M54 to M6 Link Road

**8.8 P(A) Draft Statement of Common
Ground with Environment Agency**

**M54 to M6 Link Road
Development Consent Order 202[]**

Version	Date	Status of Version
3 (P05)	3 November 2020	Issue to the ExA for Deadline 1

Drawing file: published-documents / TR010054-000263-TR010054 M54 6.2 Environmental Statement Figure 13.2.pdf

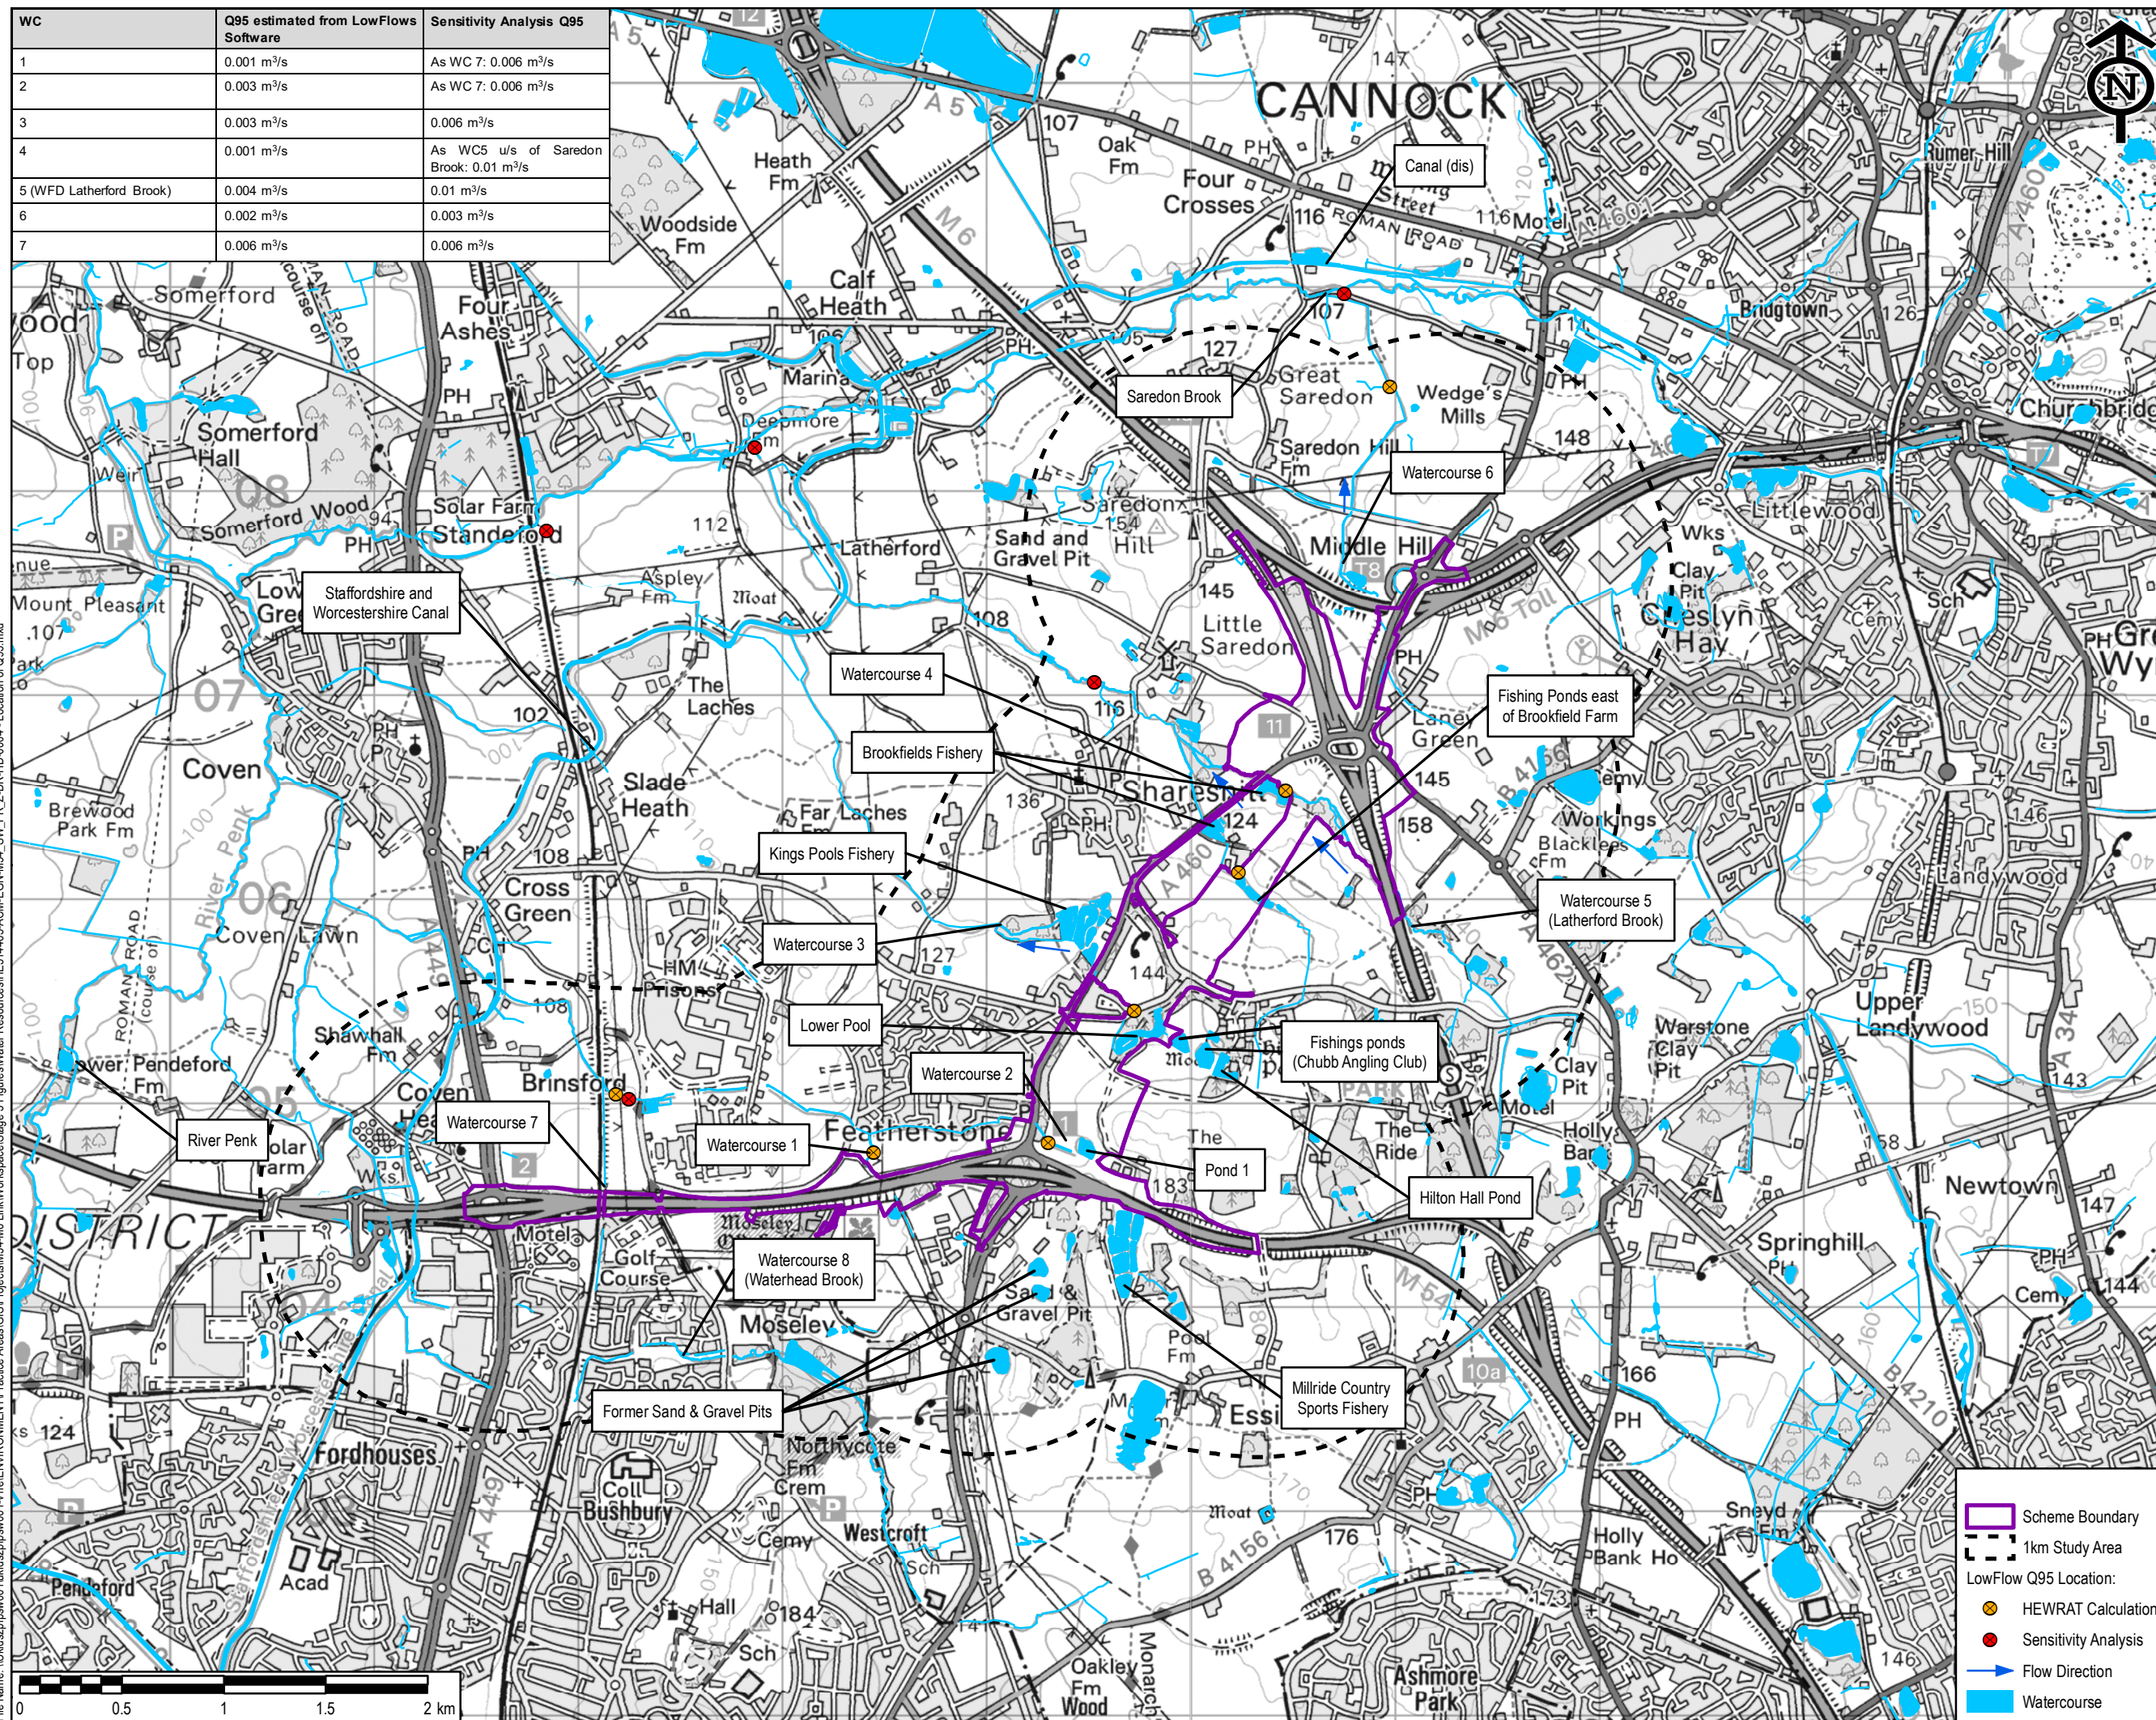
Appendix 13.4: Water Framework Directive Assessment [APP-203/6.3].	-	Impact of culverting	The report underestimates the impacts of culverting the watercourses by pointing that the impacts would be 1% of the overall watercourse. However, the WFD legislation assesses the impacts based on the activity and culverting is classified a high risk activity.	Paragraph 13.9.90 of Chapter 13 [APP-052/6.1] and Paragraph 6.2.6 of Appendix 13.4 WFD Assessment [APP-203/6.3] consider the impact of culverting on watercourses so that the significance of the effect could be determined (taking into account the proposed mitigation) but also, in the case of the WFD Assessment, to determine whether the effects are significant at a local or water body level.	Under discussion	High

Appendix 13.4 Water Framework Directive of the ES [APP-203/6.3]		Drainage strategy – water quality	<p>The Environment Agency have further concerns regarding the water quality within the proposed 408m of watercourse if these are part of the SUDs network for the road. It would be difficult to say the scheme is WFD compliant without seeing these details.</p>	<p>Commitment D-WAT6 in the OEMP [APP-218/6.11 and subsequent revisions] states that the ditchcourses would convey treated runoff to the receiving watercourses from new treatment ponds. As shown on the Outline Drainage Works figures [AS-072/2.11] (Sheets 3-5), these would be provided for drainage ponds 1 to 4 (currently the outfall from Pond 5 would be a pipe and engineered outfall, but</p>	Under discussion	High

ES Chapter	Paragraph Reference	Sub-section	Environment Agency Comment	Highways England Response	Status	Agreement likely?	
						APP? ¹	IP?
				<p>This was done by expressing the length of channel to be lost as a percentage of the immediate reach it was in (i.e. between confluences with other tributaries) and as a percentage of the designated water body length. It is acknowledged that this is a simplistic and over precautionary a presentation of the impact as it does not show the effect of the culverting on the full length of the tributary, nor does it consider the whole catchment effect (i.e. the culverts proposed are not on the main stem of the WFD watercourse as shown on the WFD Catchment Data Explorer website and which represents the published length of the water body in the River Basin Management Plan (RBMP)), yet the length of other minor tributaries to this WFD water body have not been taken into account. A more detailed analysis of the length of channel to be culverted expressed as proportions of the tributary, the published length of the relevant WFD water body (i.e. main stem), and published length of the relevant WFD water body plus tributaries (with and without an estimate for existing culverts) is provided in Table 1, Appendix B of this SoCG (note that these are estimates determined through GIS analysis of digital Ordnance Survey</p>
